SUBMISSION

Proposal: Alexandria Park Community School
Redevelopment (SSD 17_8373)

SUBMISSION
ALEXANDRIA PARK COMMUNITY SCHOOL REDEVELOPMENT (SSD 17_8373)

This submission is made on behalf of the owner of Lot 1 DP 346555, Nos. 135 – 139 McEvoy Street, Alexandria (an adjoining property to the immediate south).

Figure 6 – Site Plan of the Proposal

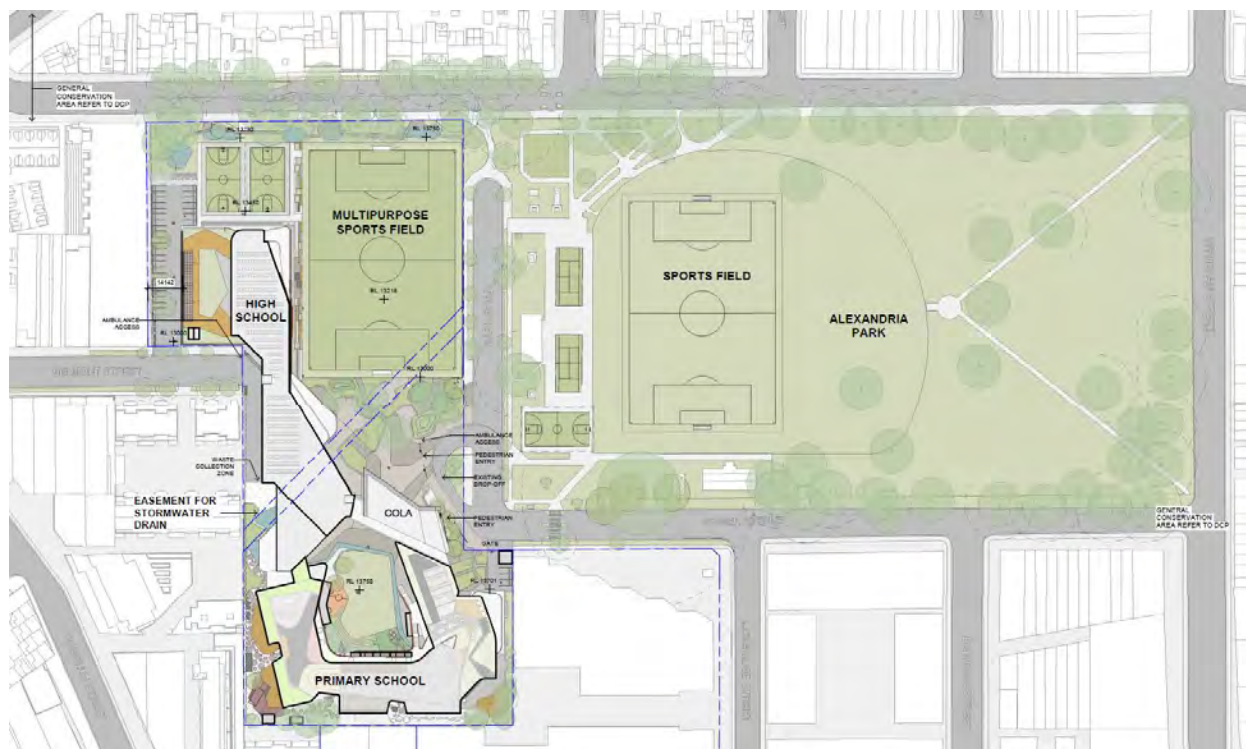
It is noted there are 2 x unspecified building structures located immediately adjacent to our boundary (see figure below extracted from the Architectural Drawings). These structures are not labelled upon the floor plan, nor represented in sections or elevations. It is therefore difficult to determine their impacts upon Nos. 135 – 139 McEvoy Street. They do however significantly reduce the ability for the available setback area to be utilised for landscaping in scale with the proposed development, and as a consequence, further exacerbate issues in relation to the proposed 'Homebase' building's height and setback from the common boundary.

It is alternatively suggested that the proponent reposition the 'Homebase' modules for the primary school to ensure a minimum 6 metre landscaped setback to the common boundary, and modify the setback of the rooftop structure to ensure no greater overshadowing impact than a building otherwise compliant with a 6 metre setback and a maximum 15 metre building height.

Some form of landscaping must be introduced adjacent the common boundary to assist in reducing the scale of intended development, and to assist providing an appropriate green buffer and visual privacy between the adjacent land uses.

Figure 16 – Height non-compliance

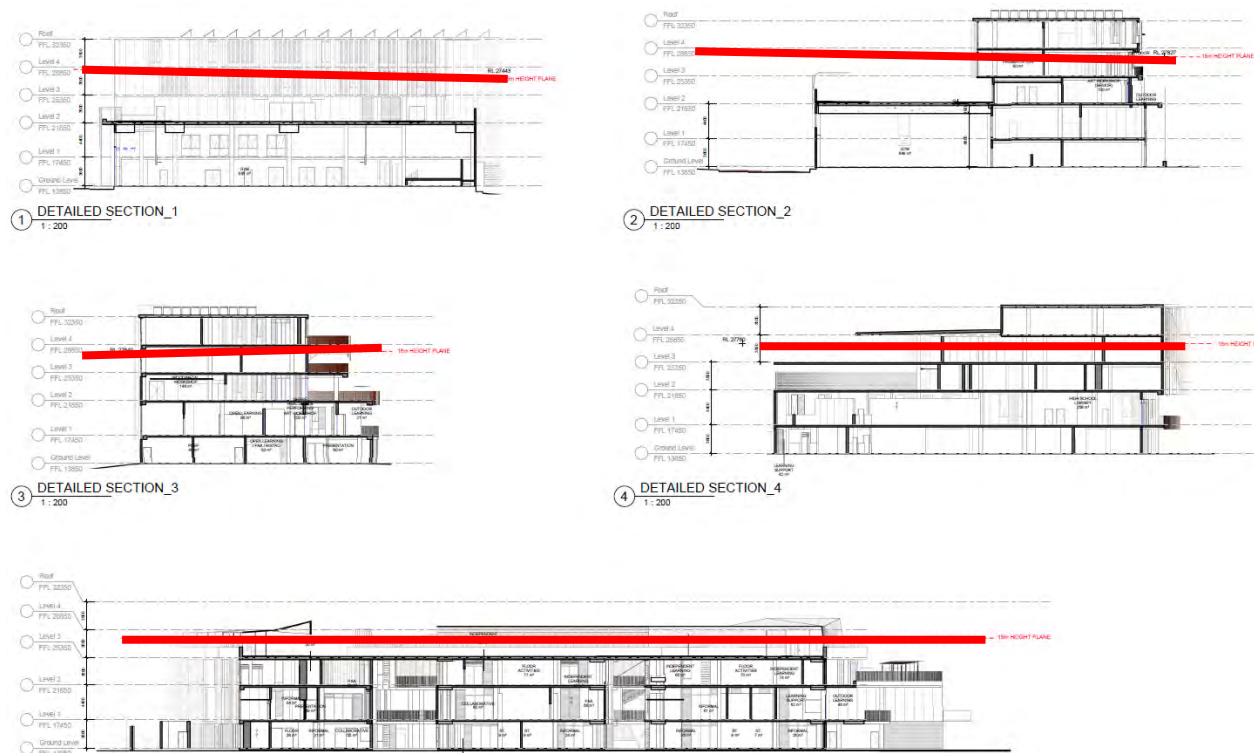
The Sydney Local Environmental Plan 2012 prescribes a maximum building height of 15 metres for the subject redevelopment, measured from ground level existing to the topmost point of the building. Many of the proposed buildings exceed the 15 metre development standard, including the 'Homebase' buildings adjacent the common boundary with Nos. 135 – 139 McEvoy Street. These buildings are also noted to be setback only 5 metres from the common boundary (although building setbacks to site boundaries are difficult to determine from the detail provided by the architectural plans).

As a consequence, concern is raised in relation to the proposal’s failure to achieve a 6 metre separation to the common boundary and to comply with the prescribed building height limit. The resultant impact may either lead to a reduction in the development potential of Nos. 135 – 139 McEvoy Street, or to a loss of amenity and sunlight to the units and their private outdoor spaces at the lower levels of any future development.
